Subject: FW: Planning Consultation on: LU/160/14/PD

APPLICATION LU/160/14/PD

Site Address: 49a Horsham Road Littlehampton

Description of Works: Prior Notification under Class 1A for change of use from off licence (A1 retail) to a 2 bedroom flat (C3 dwellinghouses) with an internal area of 74.38sqm

Proposed

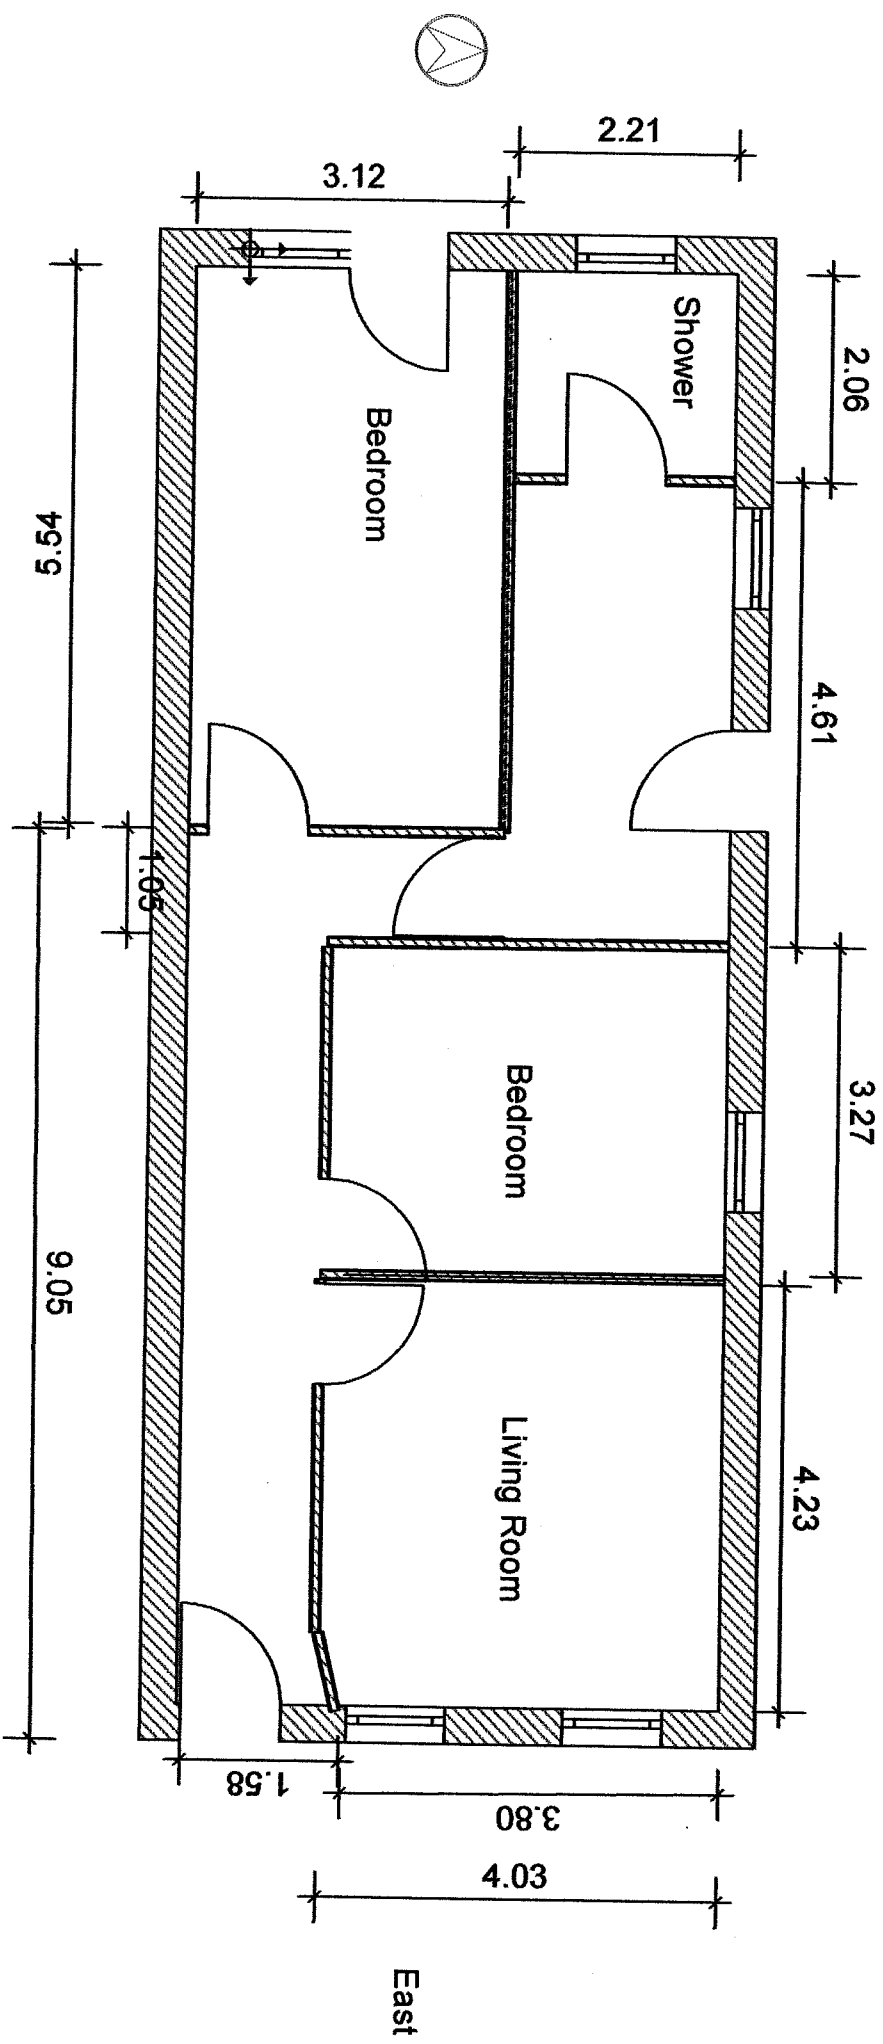
Based on the application this is not acceptable no provision has been made for a kitchen.

The possible location (the area near the toilet is unacceptable based on size and shape (once work surfaces and provision for cooker/washing machine ect ther access to the bathroom is liable to be severely restricted.
